From:
Sent: 01 December 2025 20:57
To: Farzana Tabasum
Subject: Formal objection to unsafe retaining wall 2025/45/90964/E

Formal Objection – Retaining Wall Submission (Condition 16)

2025/45/90964/E

Land off Westgate Cleckheaton bd19

- NOTES:
- All dimensions in mm unless otherwise specified.
 - BLOCKS: LOCK+LOAD
GEOGRID: SECUGRID 40/40
 - INSTALLATION: Please refer to standard Manufacturer's installation guidelines.

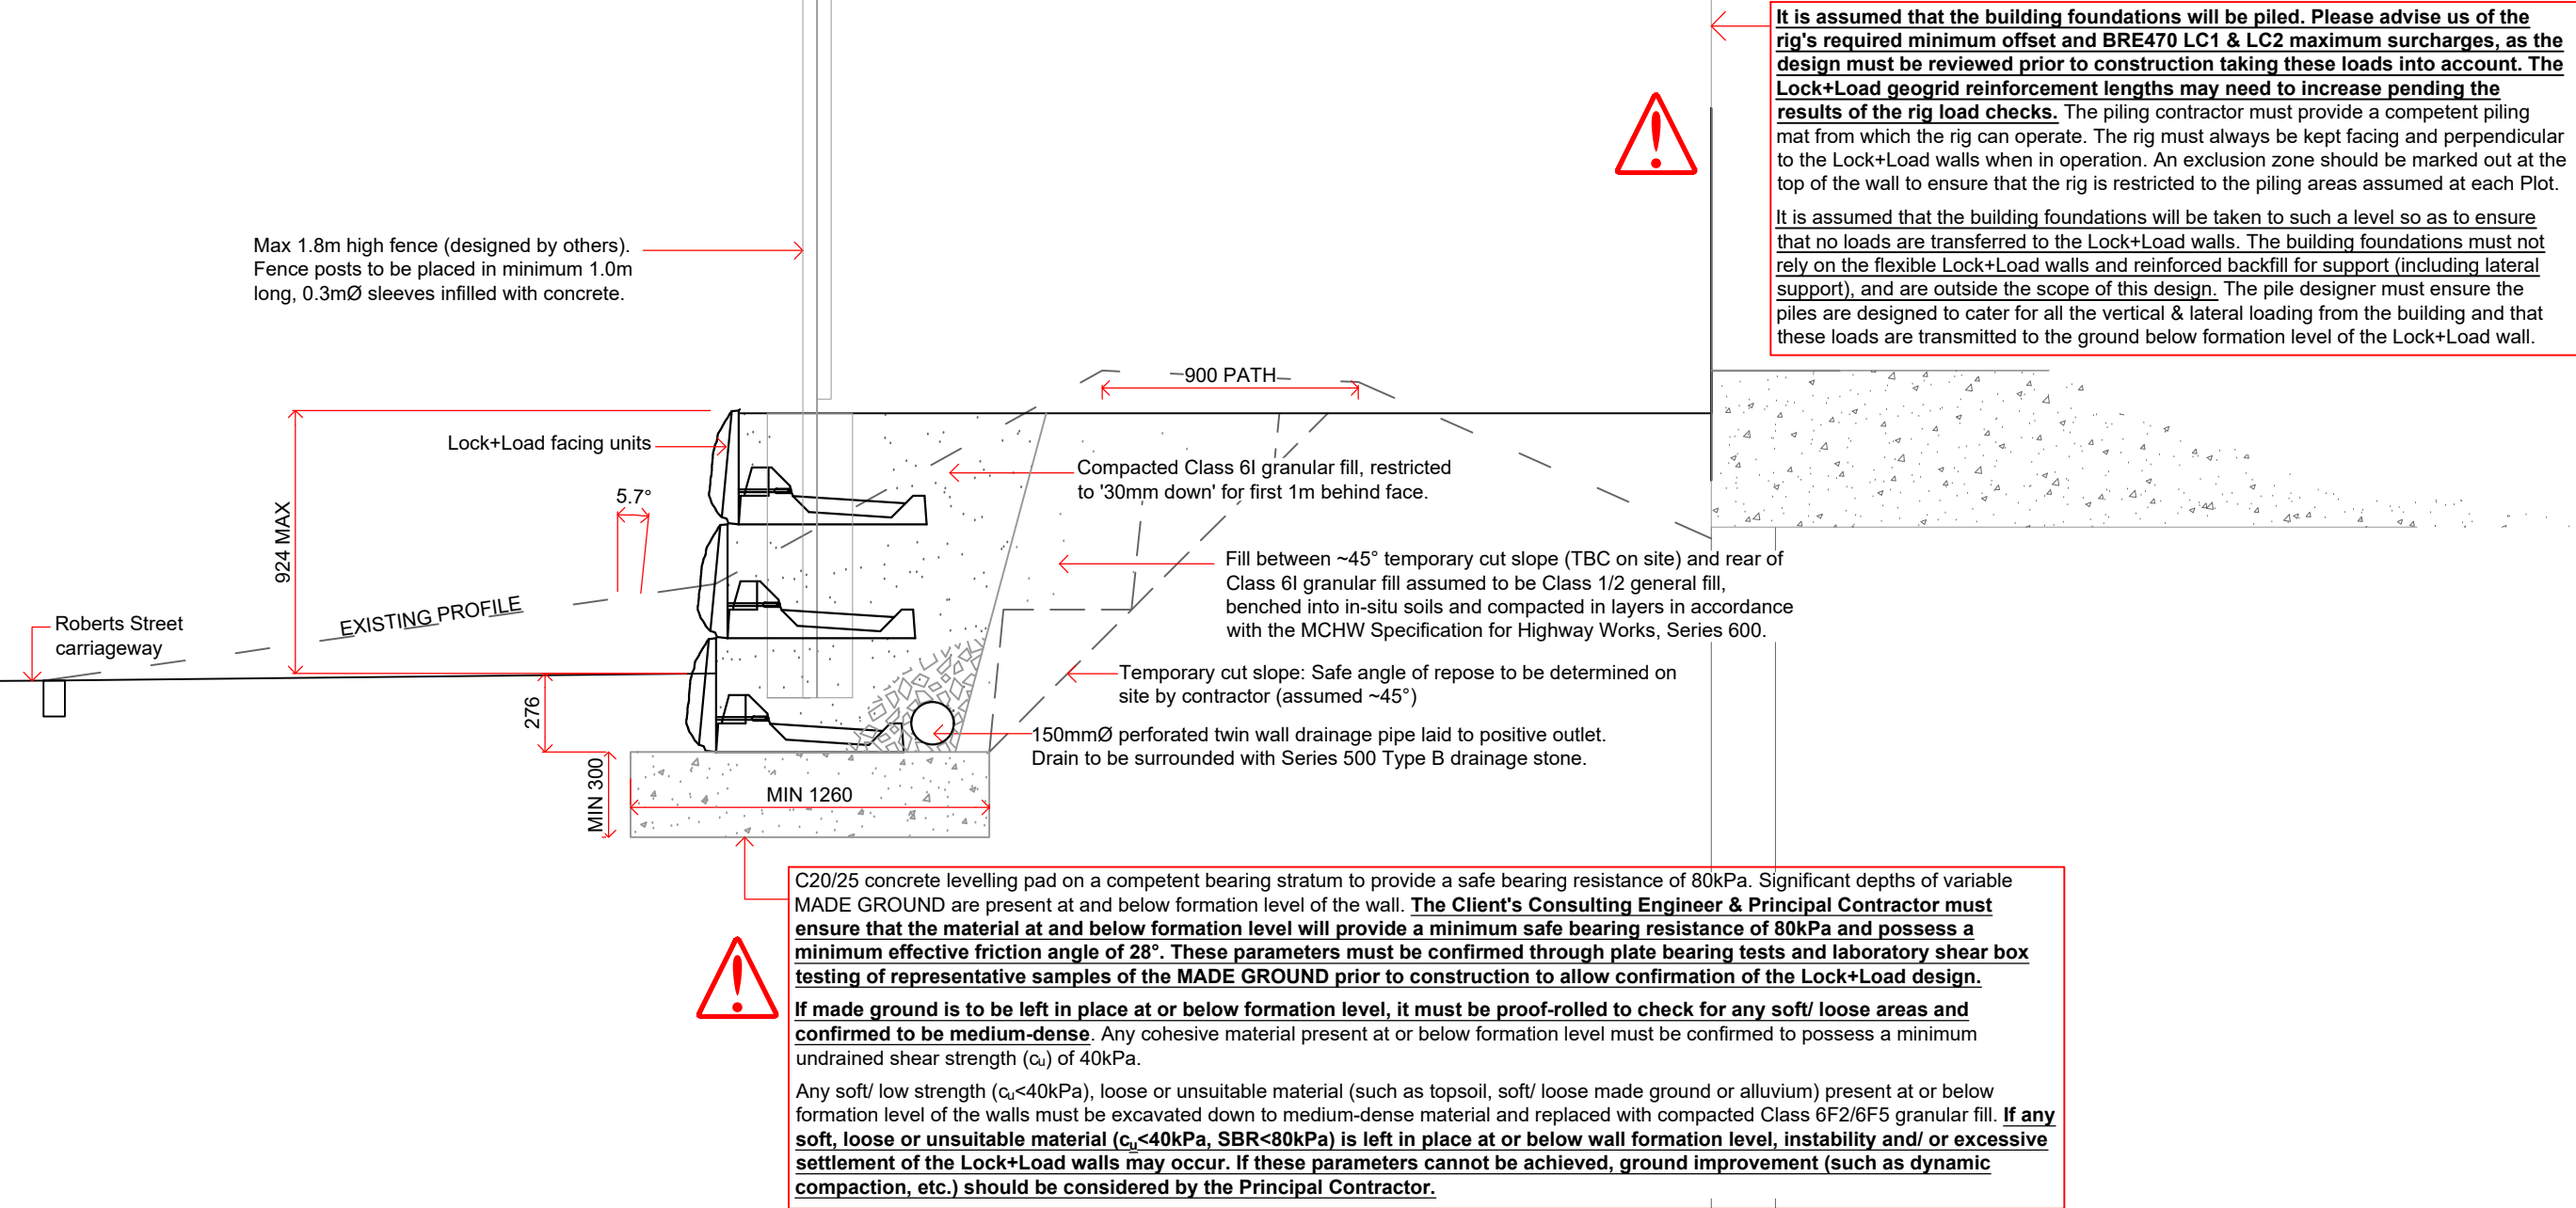
The drawings even contain a note requiring these checks to be carried out, yet they have not been completed. This omission is extremely serious given that the ground at this boundary is weak, variable and partially unstable, with collapsing trial pits, rapid groundwater ingress and inconsistent made ground containing ash, clinker, slag, brick dust and industrial waste.
